September 13, 2013

Mr. Gregory R. Olson, P.E.  
City of Albuquerque – Planning Department  
600 2<sup>nd</sup> Street NW, Suite 201  
Albuquerque, NM 87102

**RE: Church's Chicken #695 – 5407 Central Avenue NW  
Grading and Drainage Plan for Building Permit  
File No.: K11-D081**

Following are responses to the City's comments dated September 11, 2013 on the above referenced project:

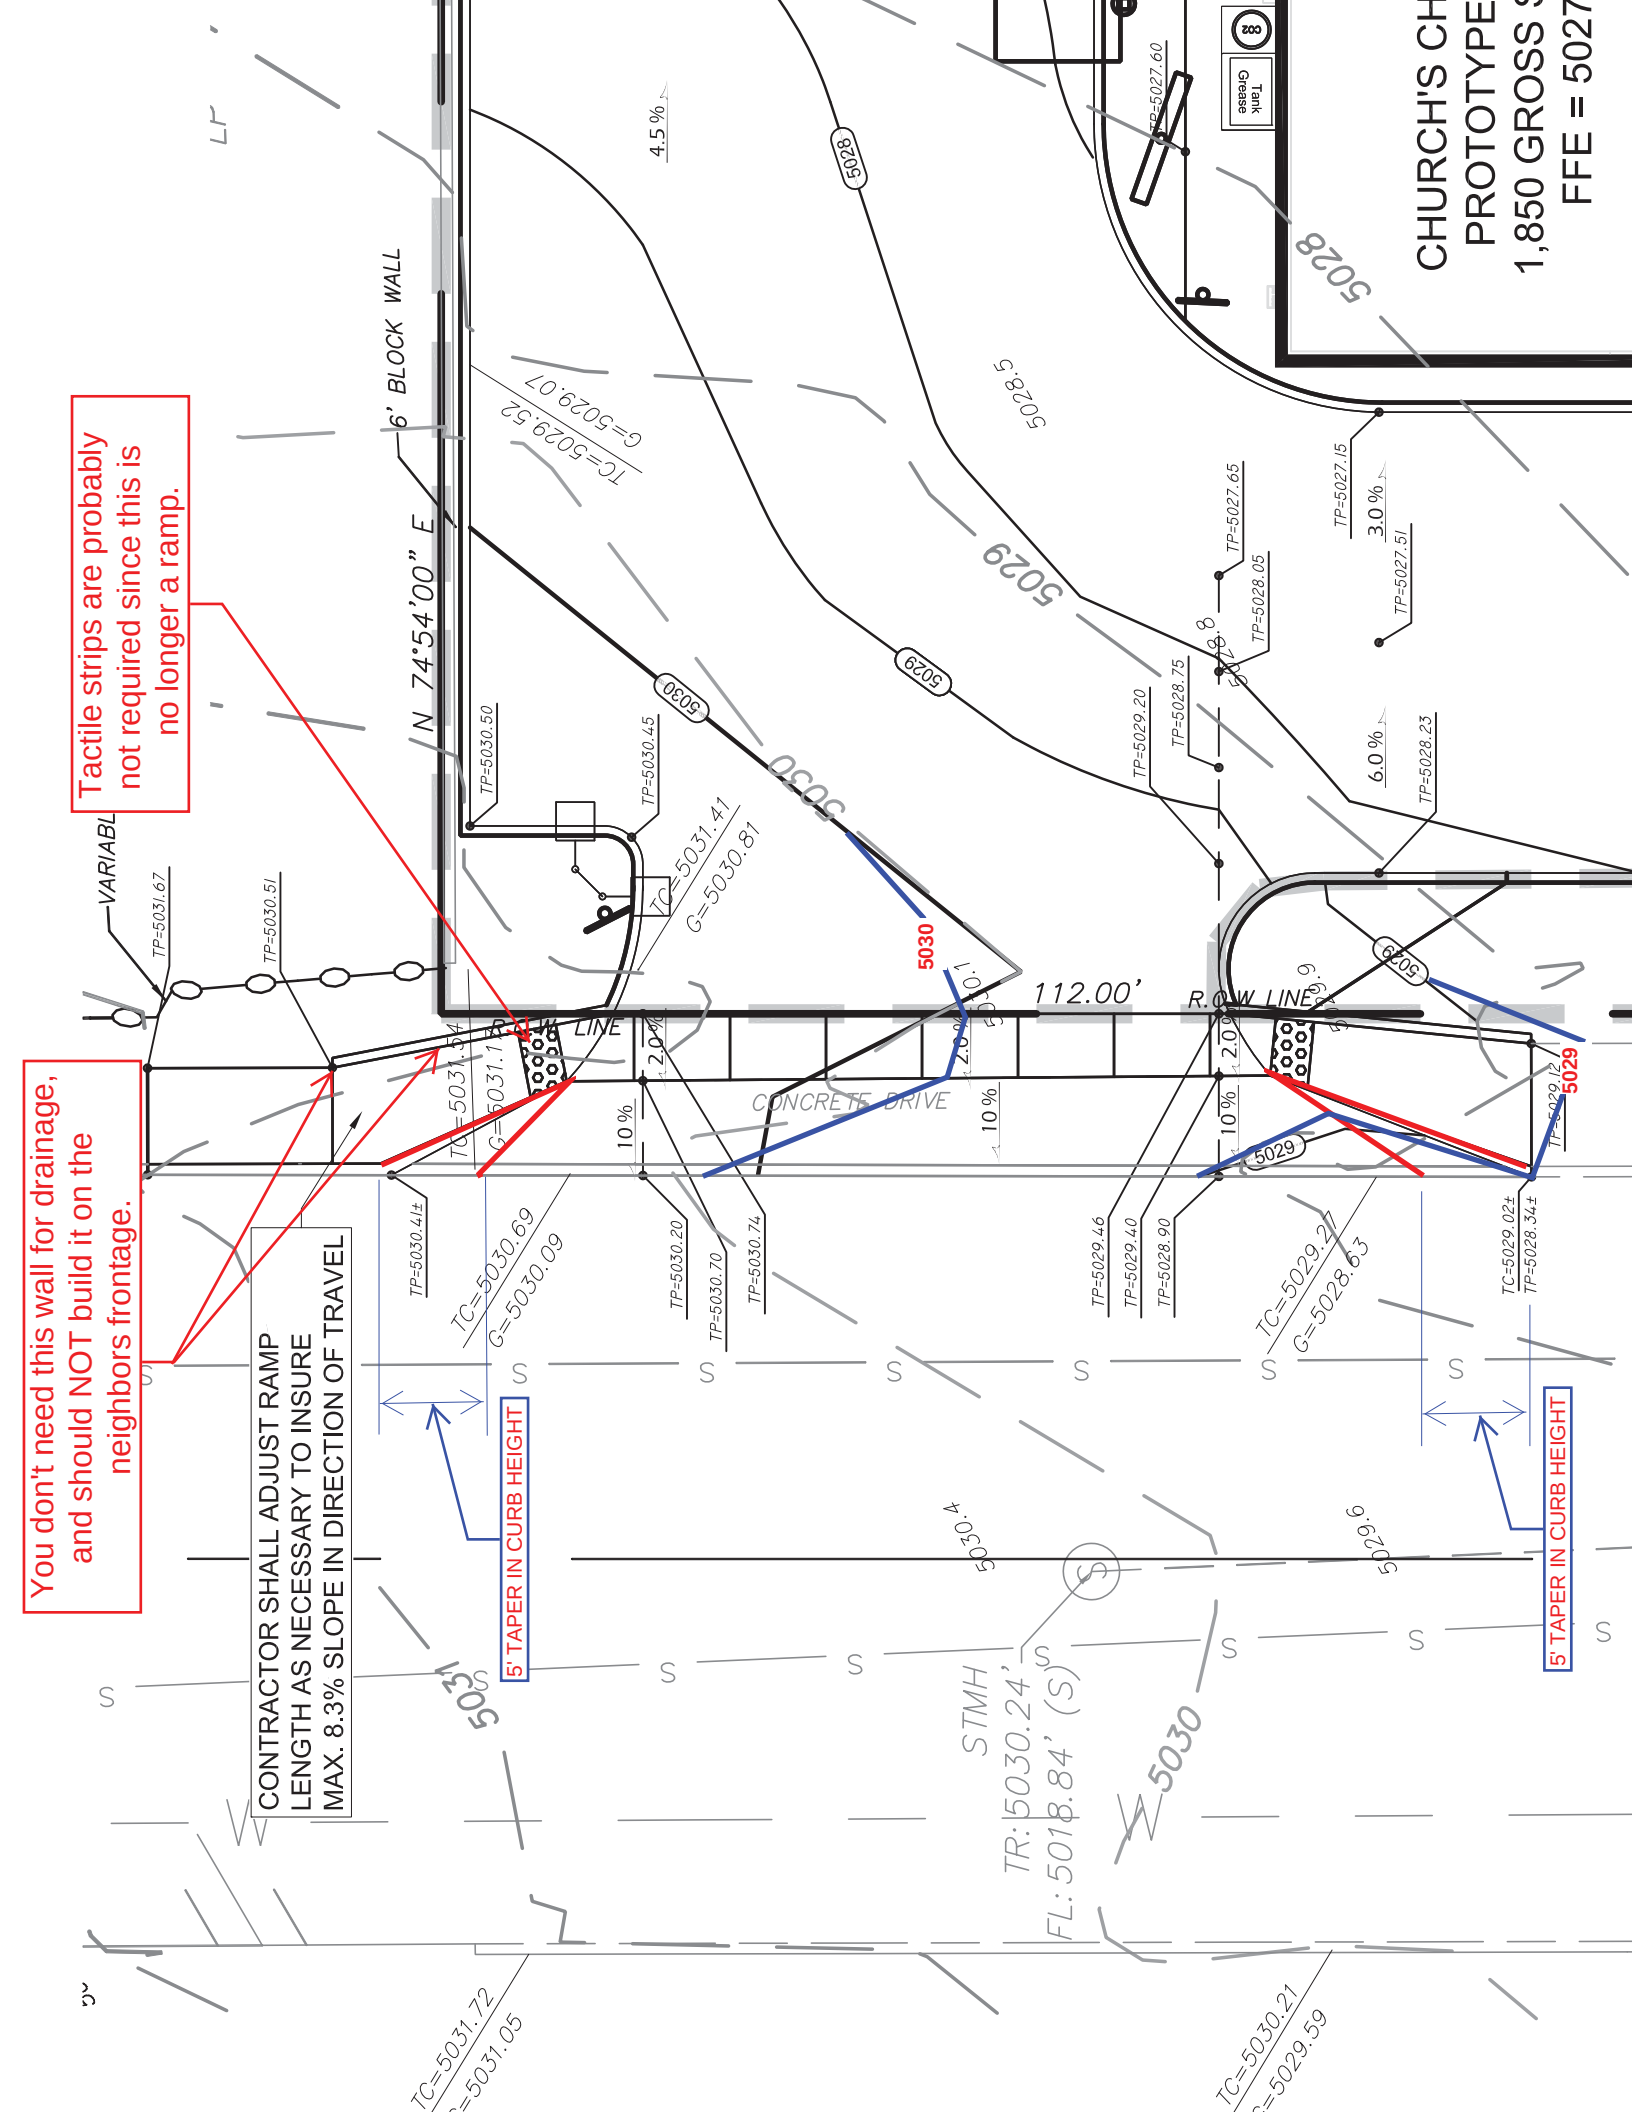
6. The west driveway entrance must include a water block to prevent street flows on Yucca from entering the site. As we discussed by phone, please consider alternate entrance designs, such as COA Standard DWG 24225 or 2428.

**Response: ADAMS acknowledges this comment and has revised the Grading and Drainage Plan. Refer to Revised Sheet C5.1.**

GRADING & DRAINAGE PLAN

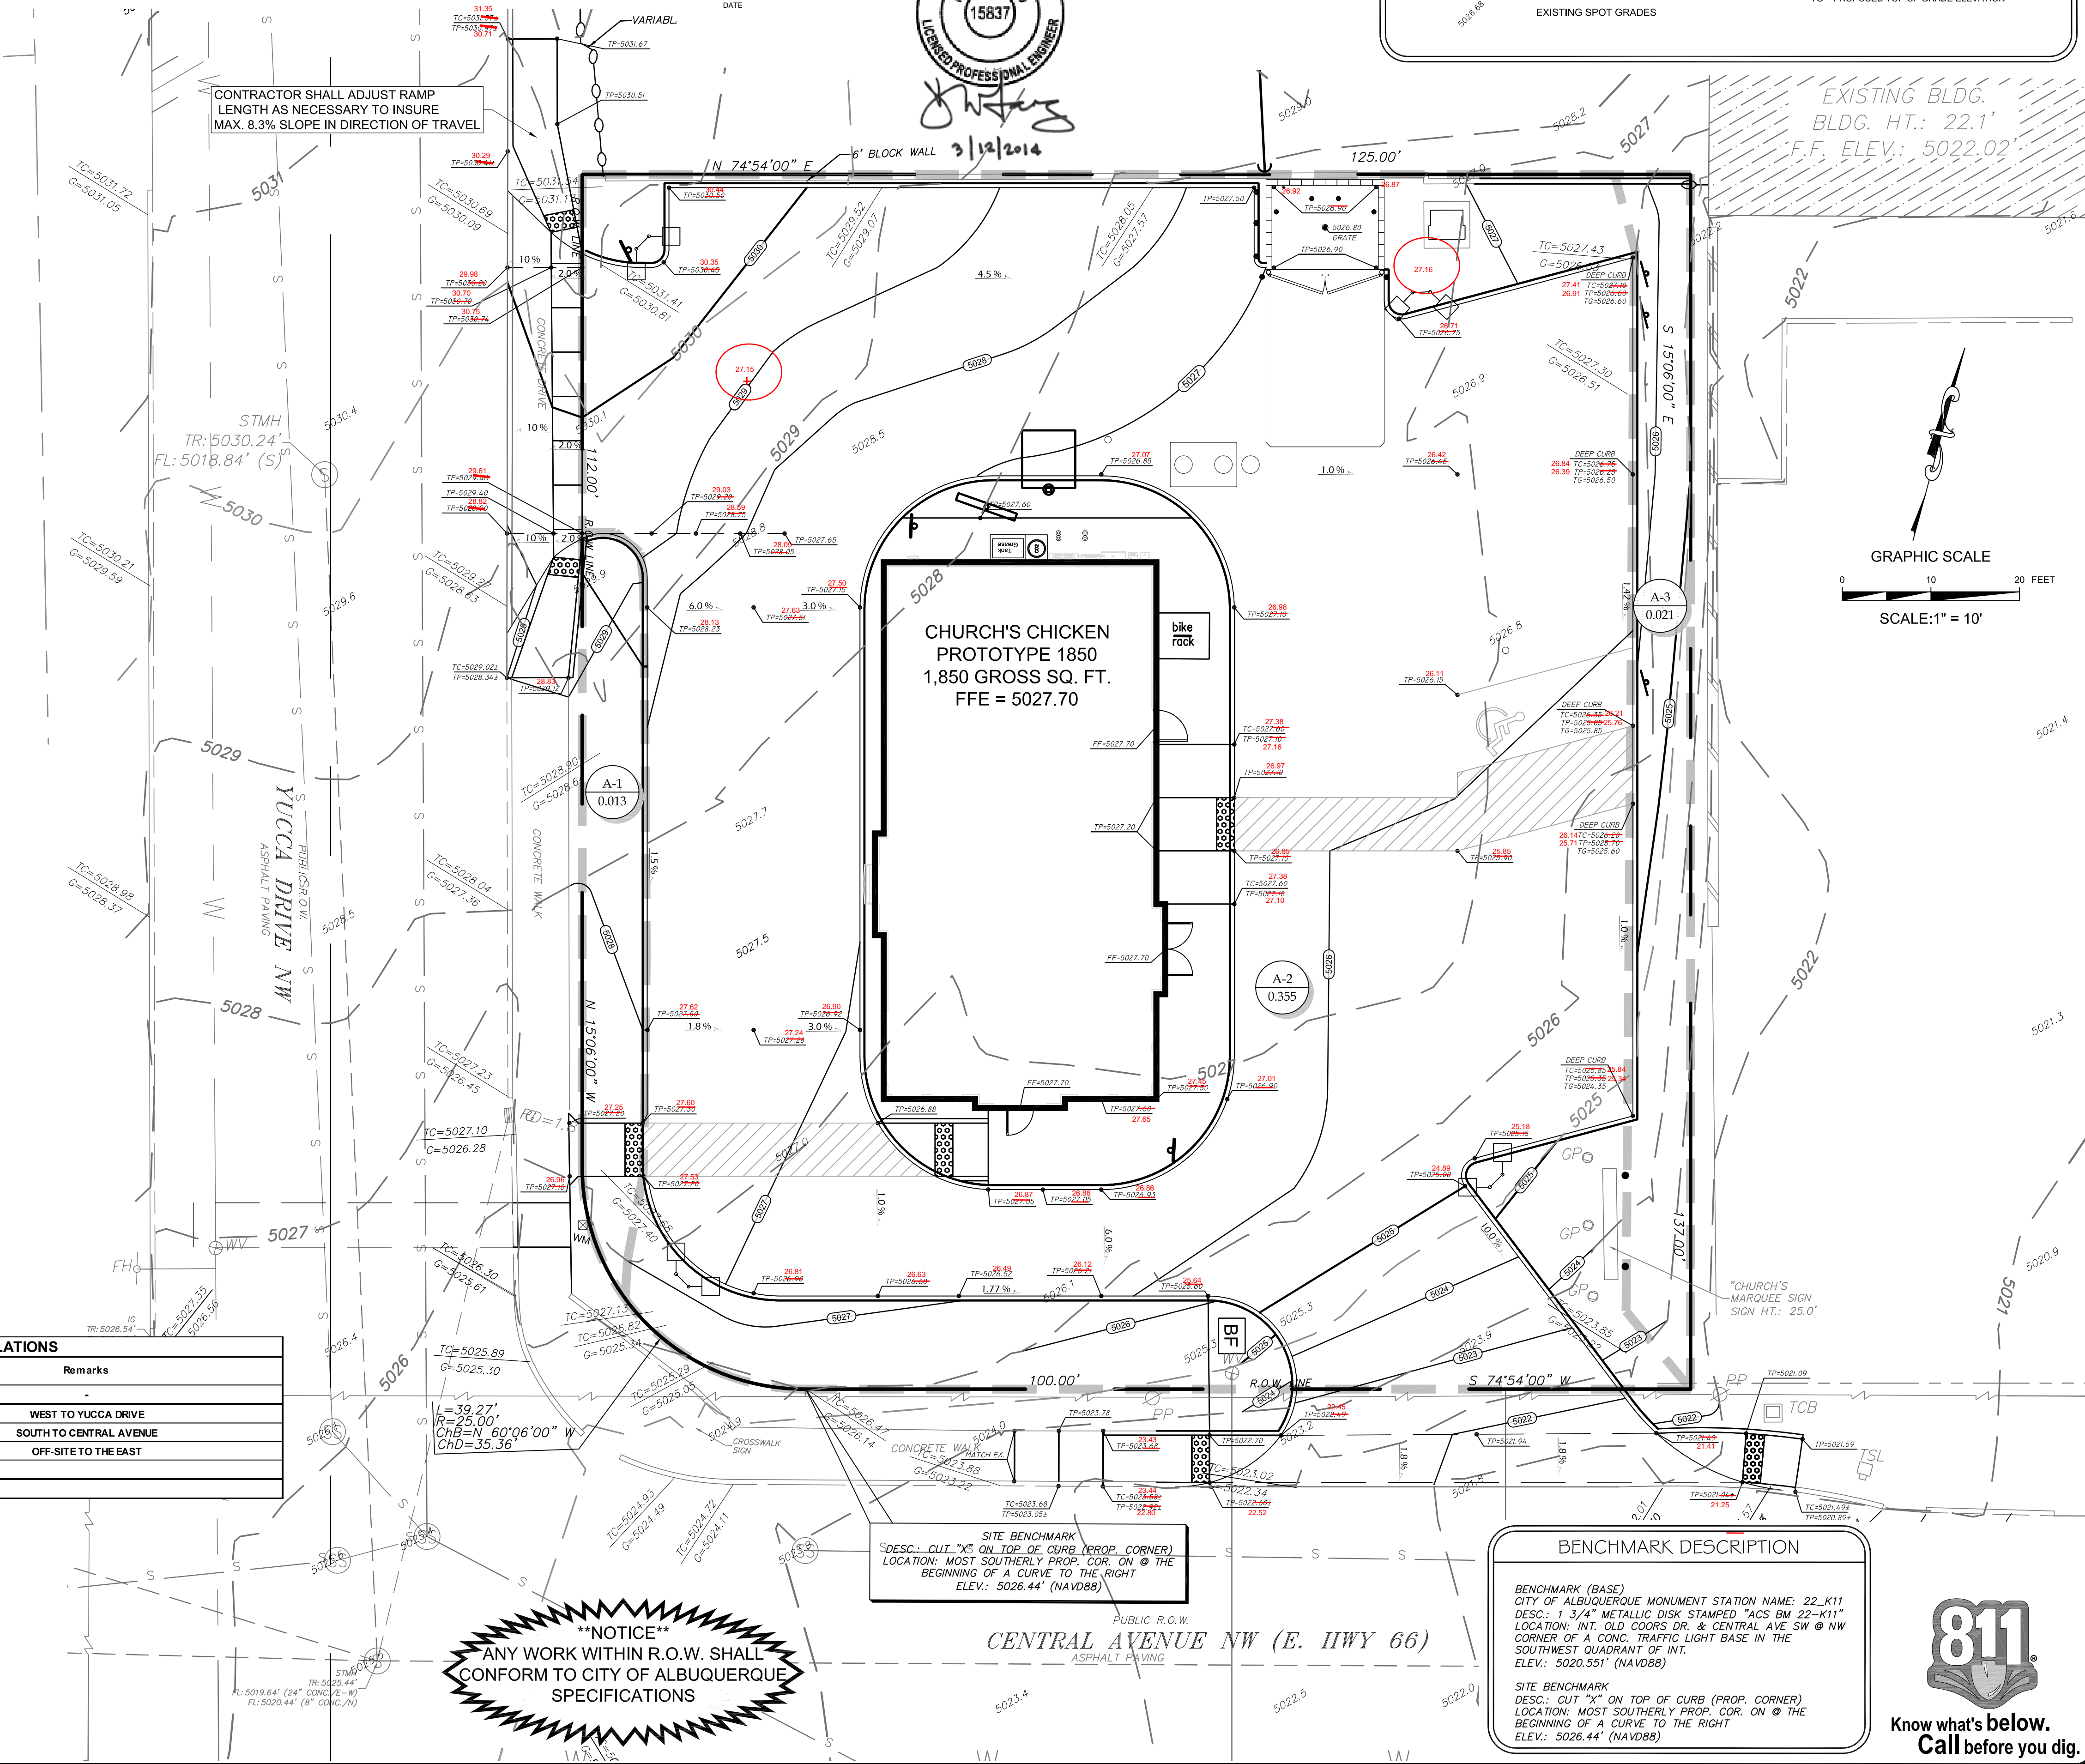
1. Wide Drainage Basin Boundary Lines used on this plan obscure some information critical to my review.  
***Response: ADAMS acknowledges this comment and has revised the thickness and shade to clarify the Grading and Drainage Plan. Refer to Revised Sheet C5.1.***

3. Provide pad elevations at the dumpster pad showing drainage to the proposed floor drain, and provide reference to the drain, which is routed to a grease trap, as shown elsewhere on sheet \_\_\_\_.

5. Clarify how the 5' drop on the east side of the lot is stabilized to prevent erosion.

***Response: ADAMS acknowledges this comment and has provided additional grade control within the trash enclosure to insure proper drainage towards the floor drain based on the City's Solid Waste Trash Enclosure Detail. We've also enclosed a copy of the Utility Plan (Sheet C6.0) for your reference of the floor drain being routed to a grease trap.***

**Response: The adjacent existing retaining wall along the east side of the site is to remain. In addition, we are matching the existing grades and providing River Rock (3"-6") for stabilization of the landscape beds.**
